**Subject:** R-6 Small Infill Design Review – 31 Fore Street

**Written by:** Caitlin Cameron, Urban Designer

**Date of Review:** Thursday, January 21, 2016 *updated and received Jan 27, 2016*

1 ELEVATIONS - SOUTH
SCALE: 1/4" = 1'-0"

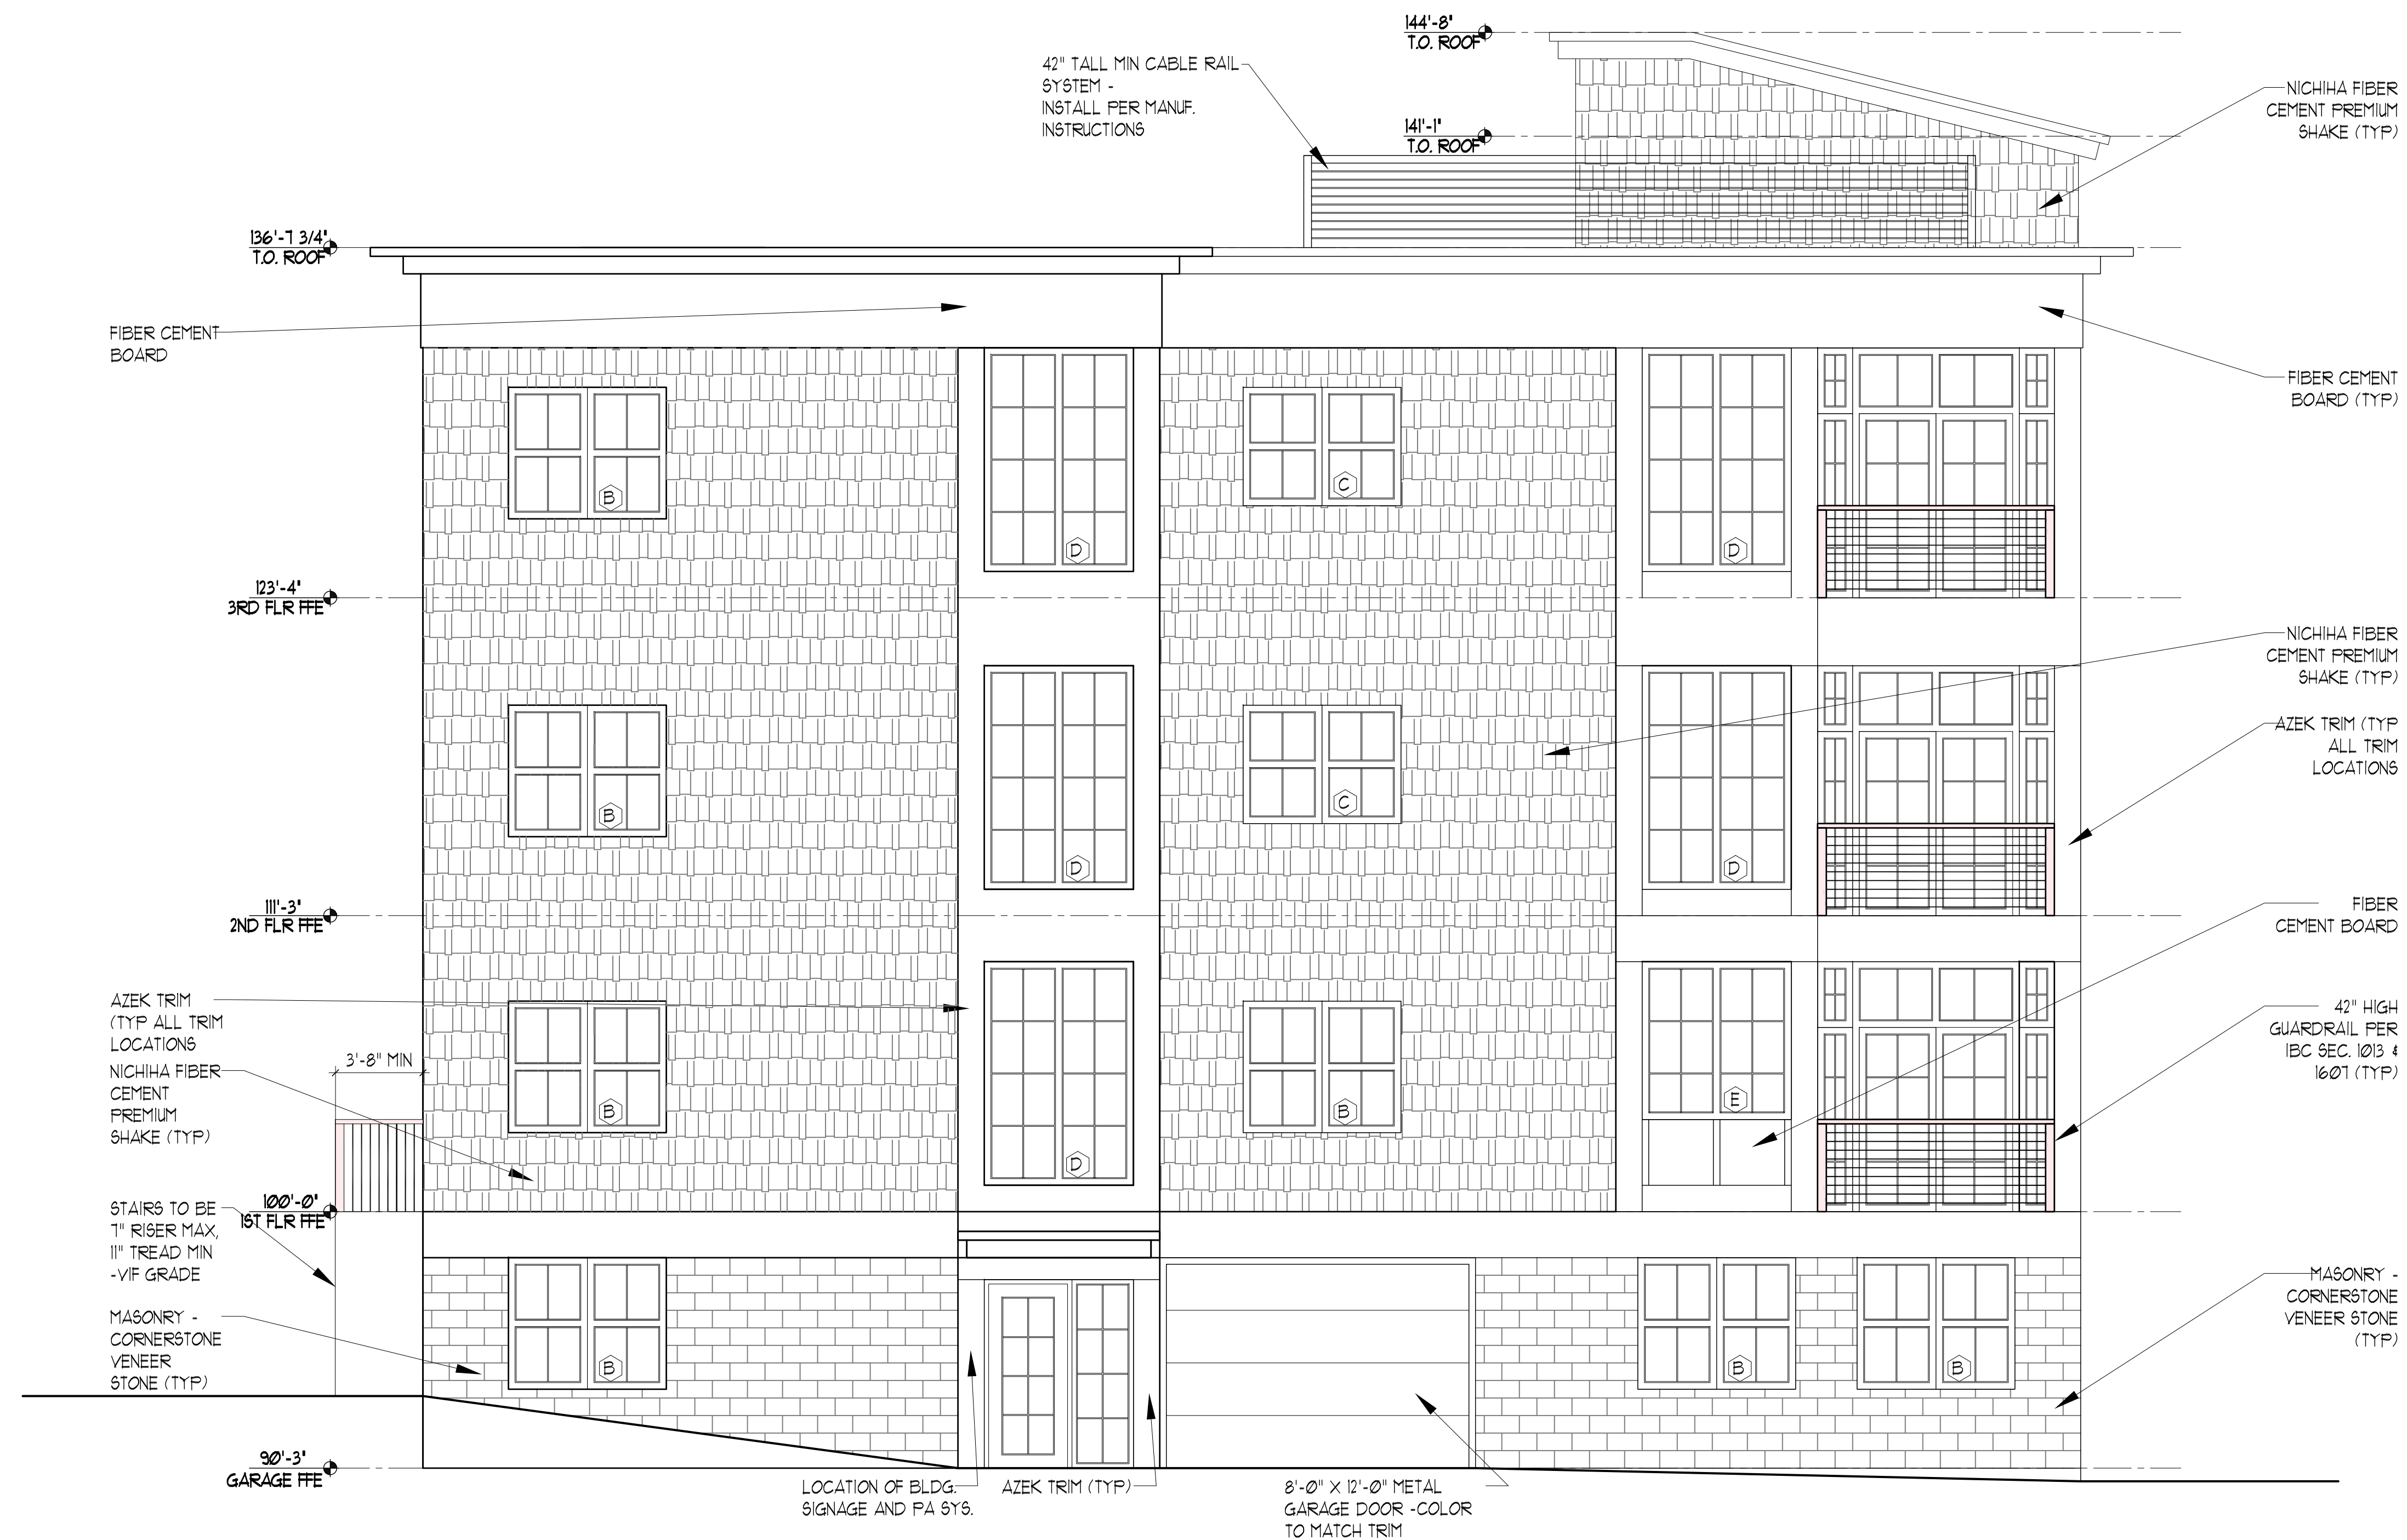
- ***C-1 Entrances***: **The main entry is not well-emphasized at the street – improve the visibility of this main entrance with elements such as an extended canopy or porch toward the sidewalk, indication at the street with the pavers or posts/markers, signage, and lighting.**
- *C-2 Visual Privacy*: Not applicable
- *C-3 Transition Spaces*: The project uses a side entry, canopy, and a vestibule for transition space.

**More detail and articulation is needed on the ground level – fenestration, landscaping, or similar**
- *F-2 Window Types:* Two window types are used, are of the same “family,” and have consistent detailing.

- **F-5 Porches, etc.:** The stoop and canopy are small in proportion to the scale of the building. There is no issue with obscuring architectural features – the entry needs to become more of an architectural feature, especially to make it visible from the street.

- **F-6 Main Entries:** The main entry is not adequately emphasized. A side entry requires indication at the street – improve the visibility of this main entrance with elements such as an extended canopy or porch toward the sidewalk, indication at the street with the pavers or posts/markers, signage, and lighting.
